CITY OF ALBUQUERQUE

DEVELOPMENT REVIEW BOARD – SPEED MEMO

DRB CASE NO/PROJECT NO: 1005039

Re: Lot 17, Block 7, Tract A, N.A.A. Unit B/sketch

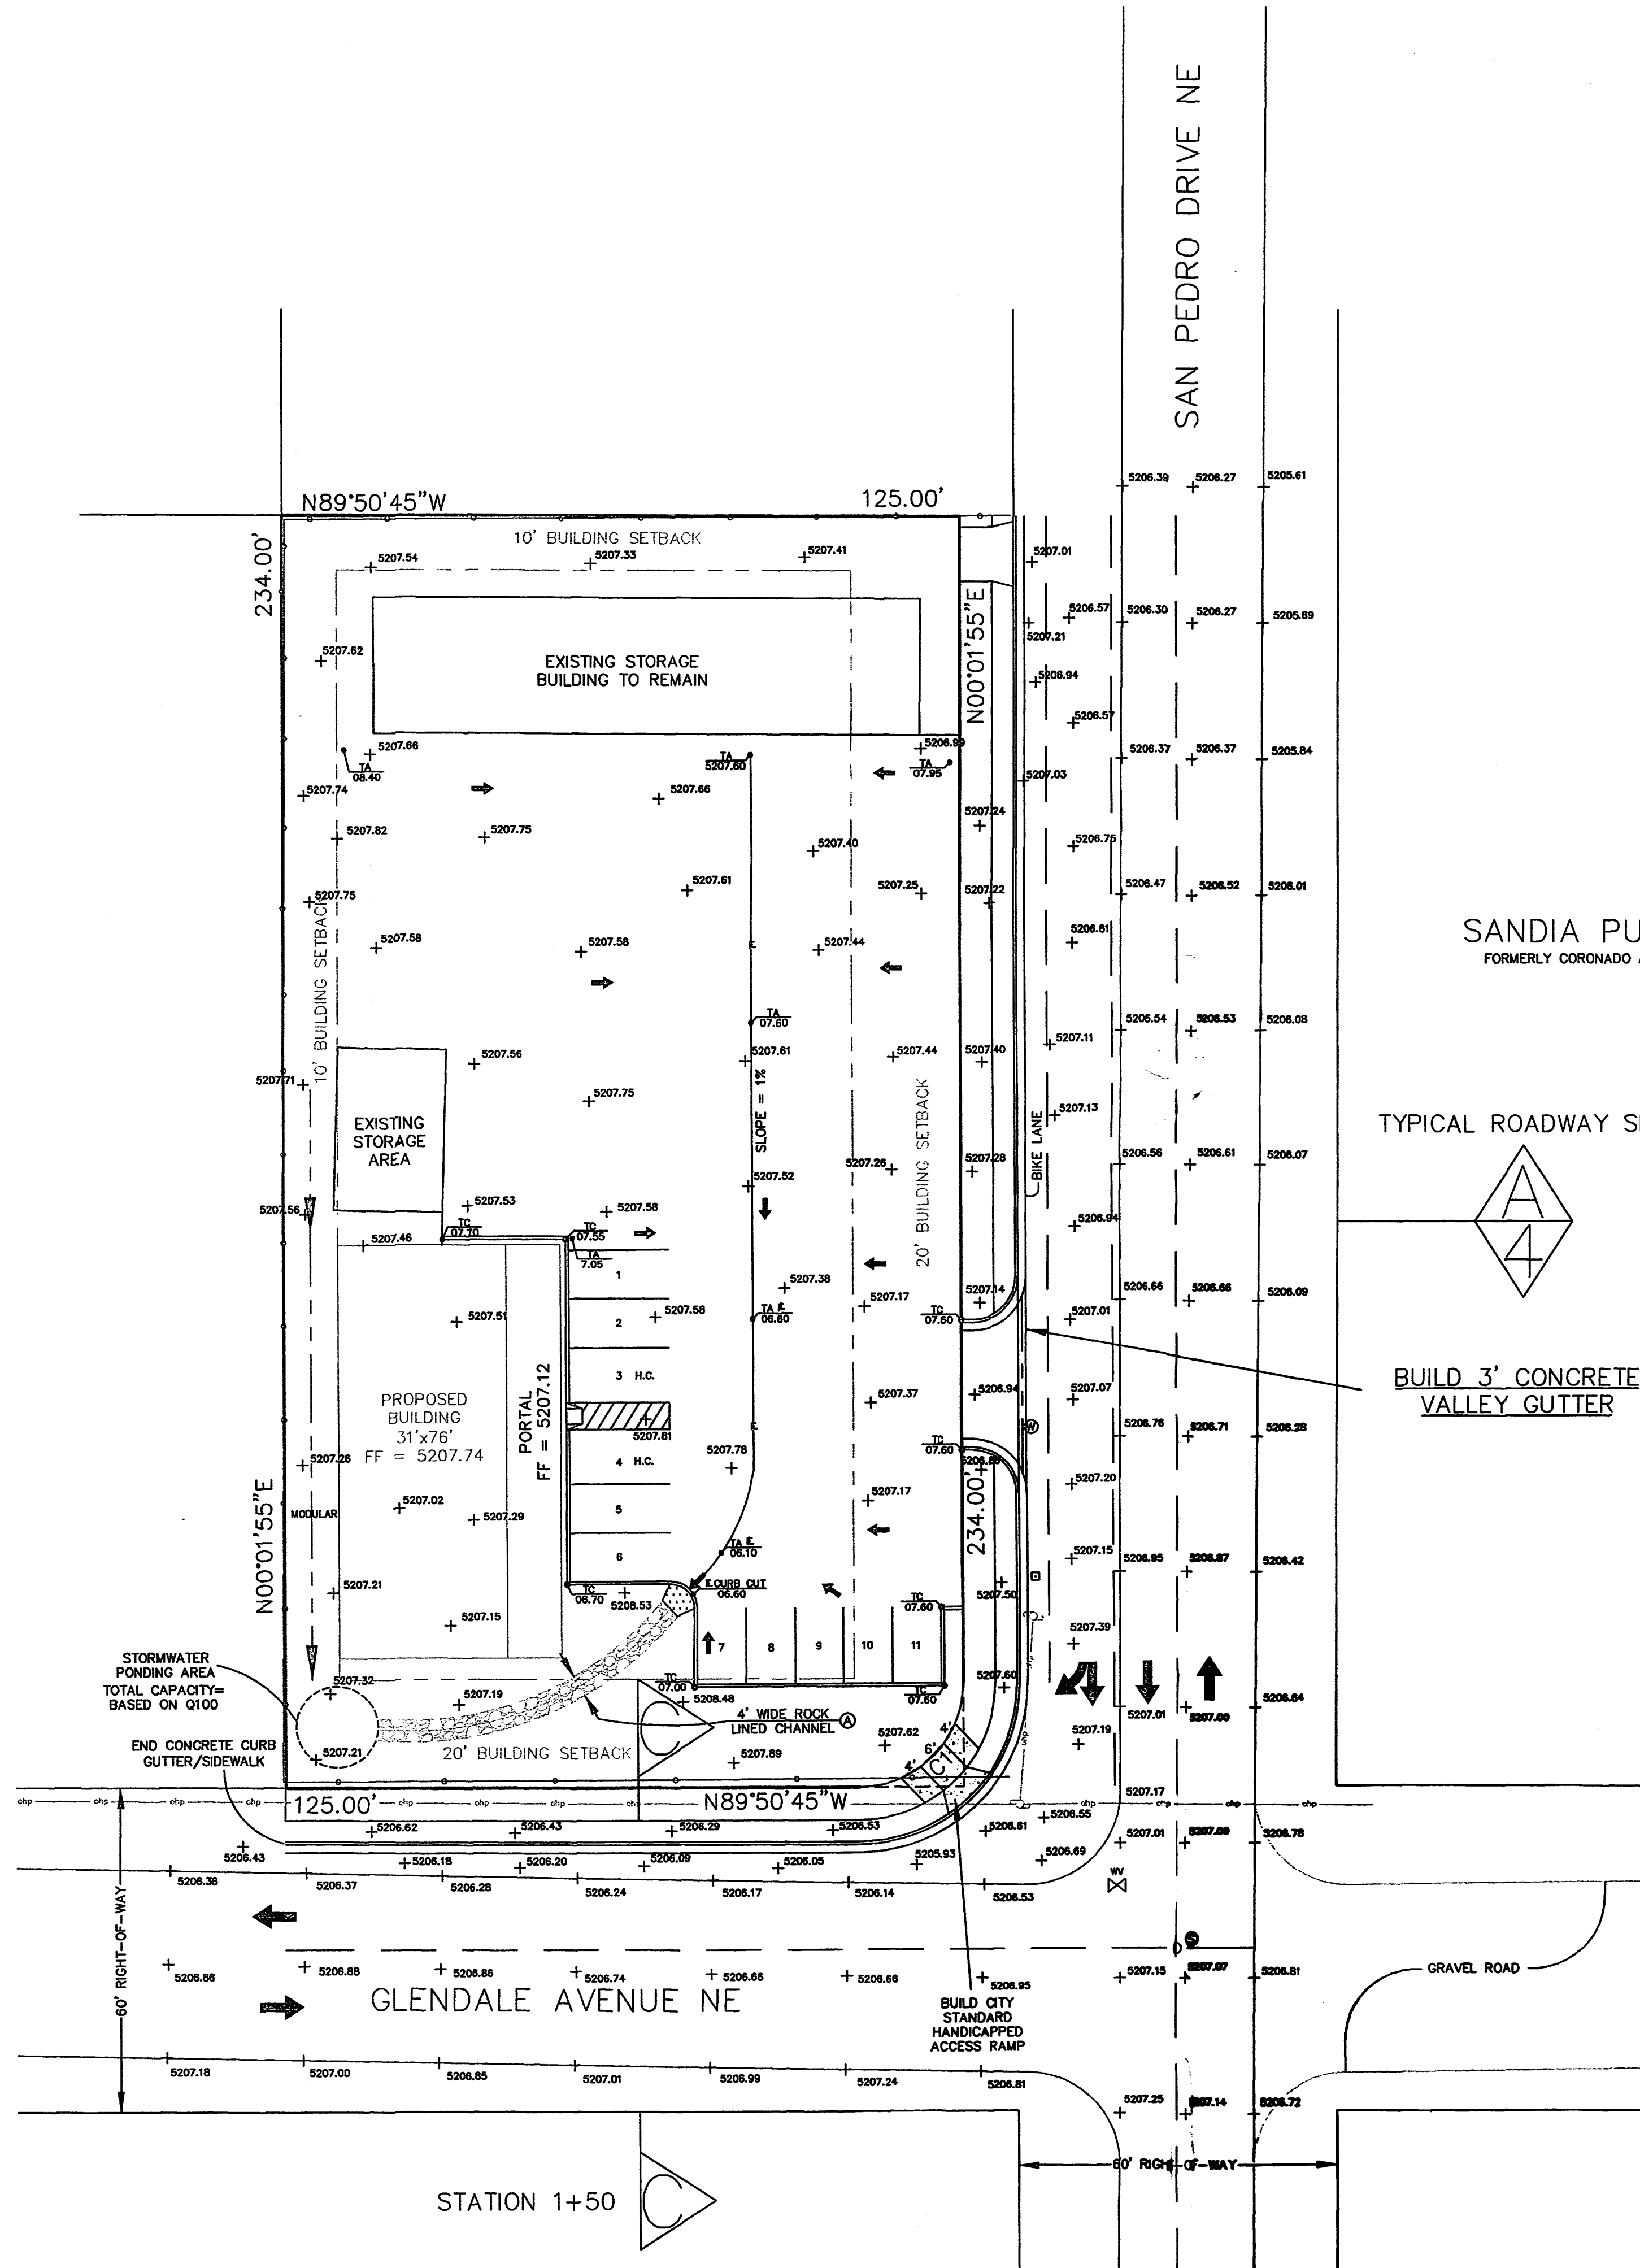
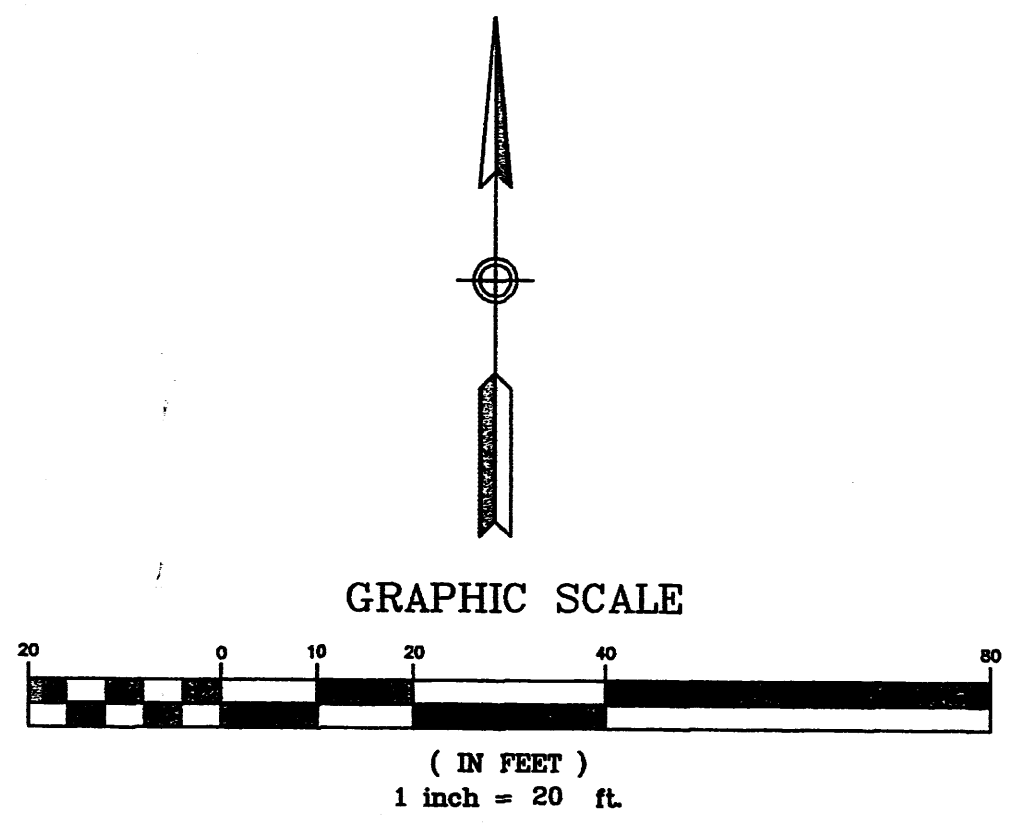
An approved conceptual grading and drainage plan is required in order to identify infrastructure requirements along San Pedro and Glendale.
